From: Stuart Taylor [Stuart@georgiangroup.org.uk]
Sent: 07 November 2011 12:28
To: Planning.Responses
Subject: FAO Mr. P Cleveland RE: Newburgh House School Lane, Arundel REF: AB/100/11/L
 Dear Mr. Cleveland,

APPLICATION NO:	AB/100/11/L
Registered:	20-OCT-11
Site Address:	Newburgh House School Lane Arundel BN18 9DR
Grid Reference:	501509 106919
Category:	Listed Bldg Con
Description of Works:	Application for Listed Building Consent to create new opening in wall between kitchen & living room

11395/ 02

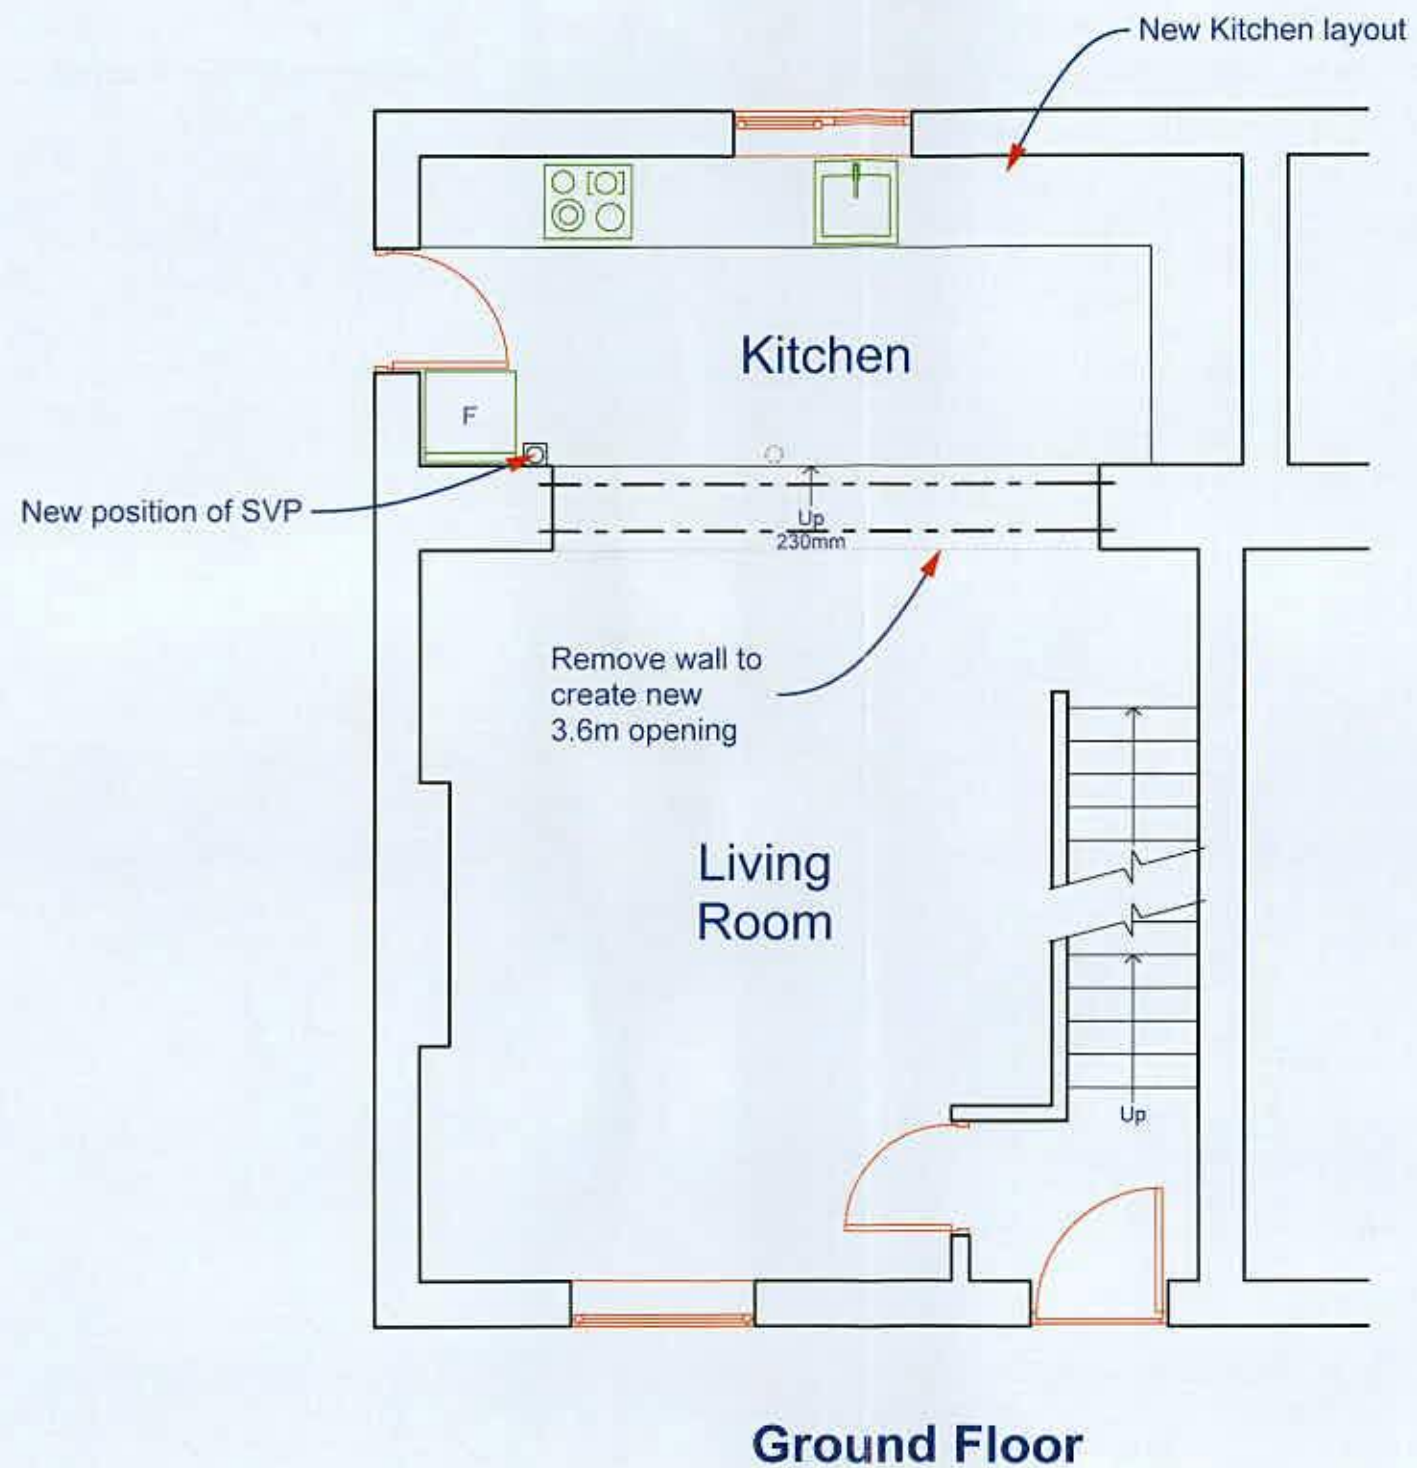
Following a review of the proposals we object to the loss of what appears to be the original rear elevation wall; the applicants have provided no information to the contrary of this.

'The fabric will always be an important part of the asset's significance. Retention of as much fabric as possible is therefore a fundamental part of any good alteration or conversion, together with the use of appropriate materials and methods of repair. It is not appropriate to sacrifice old work simply to accommodate new.' (S.6, Para. 179, PPS 5 Planning Practice Guide)

No justification has been provided for the scheme. Again, PPS 5 offers guidance:

PPS 5 states that 'Significance can be harmed or lost through alteration or destruction of the historic asset or development within its setting. Loss affecting any designated heritage asset should require clear and convincing justification.' (HE 9.1)
